Appeal Decision

Decision date: 11 January 2013

Appeal Ref: APP/C3810/A/12/2181653

Crinnis, Seafield Road, East Preston, Littlehampton BN16 1NA.

GROUND / SITE PLAN 1/100

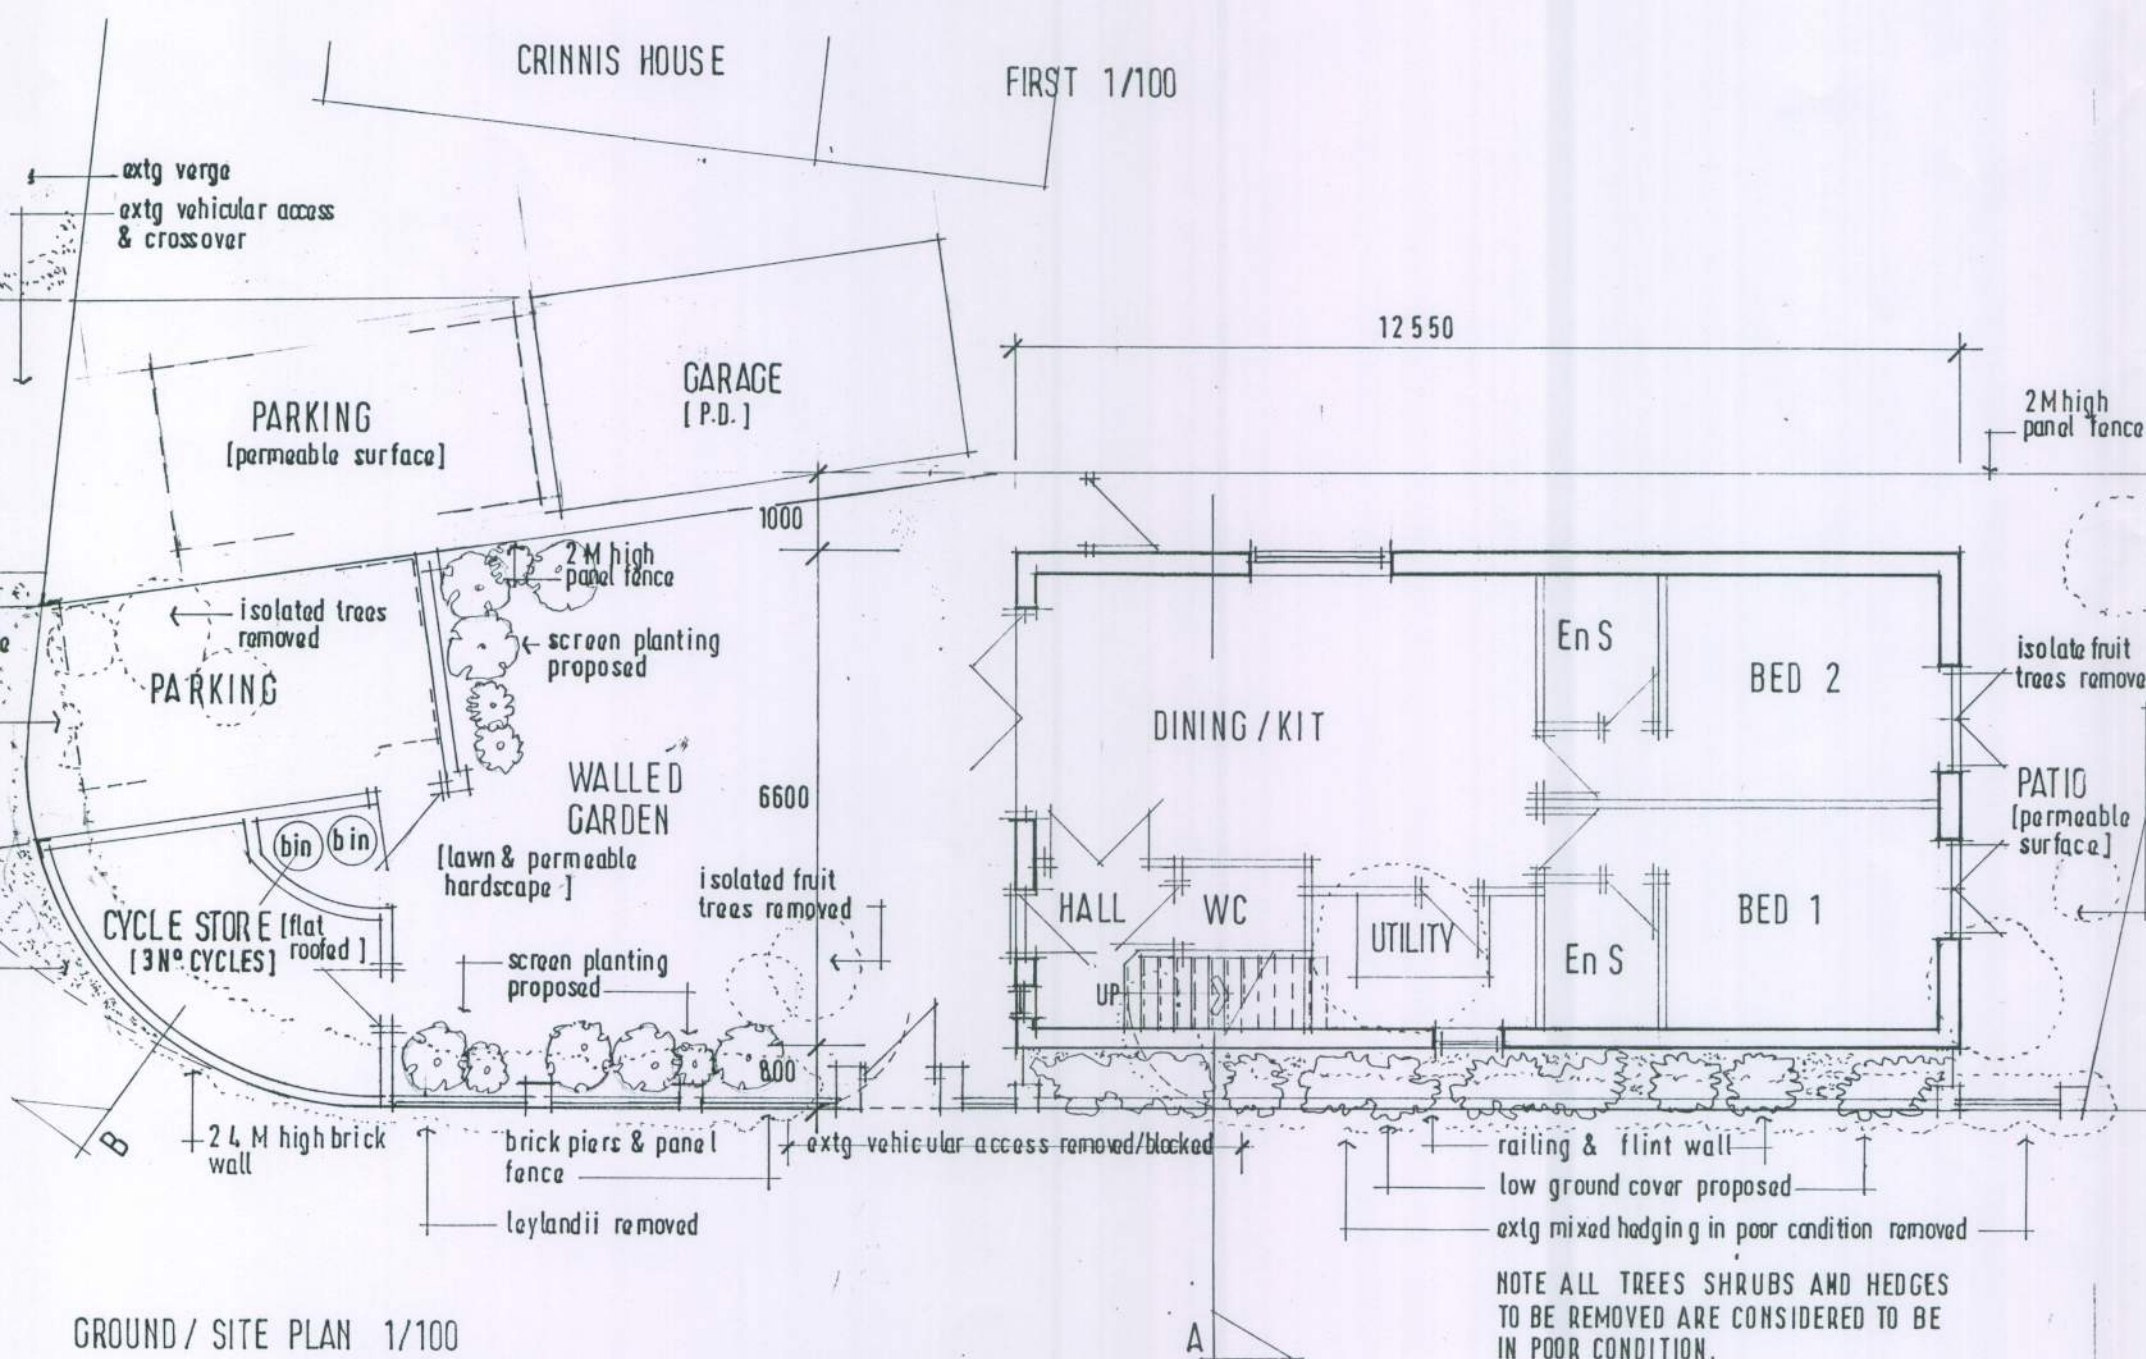
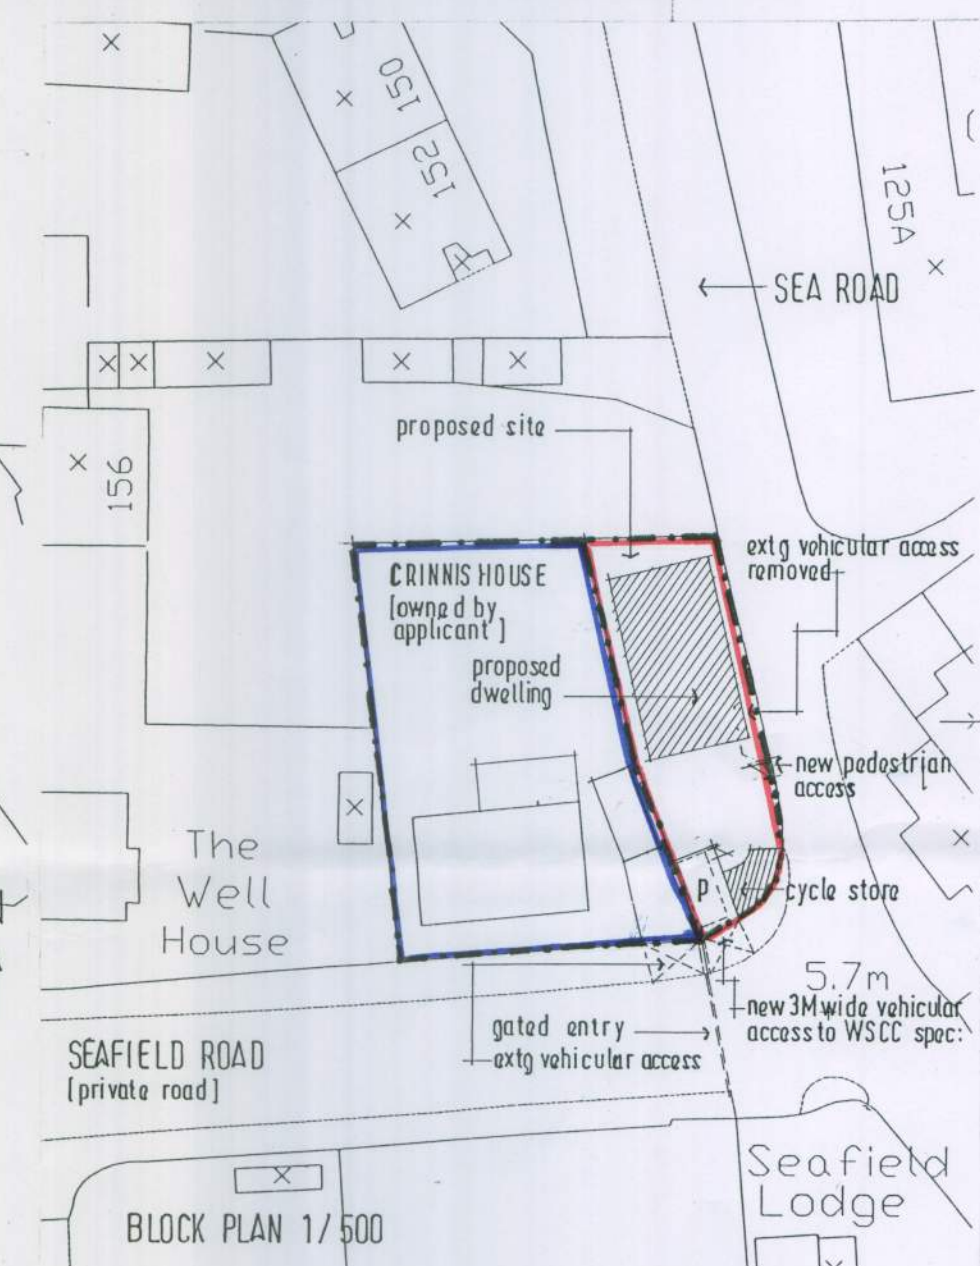
8. However, although in outline, the proposal is for a two-storey, three bedroom dwelling. The indicative plans show a dwelling of a size and siting which would, in my opinion, be too large for the site, leaving inadequate space about the building and between it and the retained dwelling at Crinnis. Furthermore, insufficient room would be retained to ensure that an appropriate level of planting and landscaping can be reinstated, particularly along the rear (north) boundary of the site and the layout would not provide an adequate garden area for the new dwelling. Thus, on the basis of the information submitted, I am not satisfied that a dwelling of the size proposed could be accommodated on the site, and the proposal would therefore introduce a cramped form of development which would not complement its surroundings.
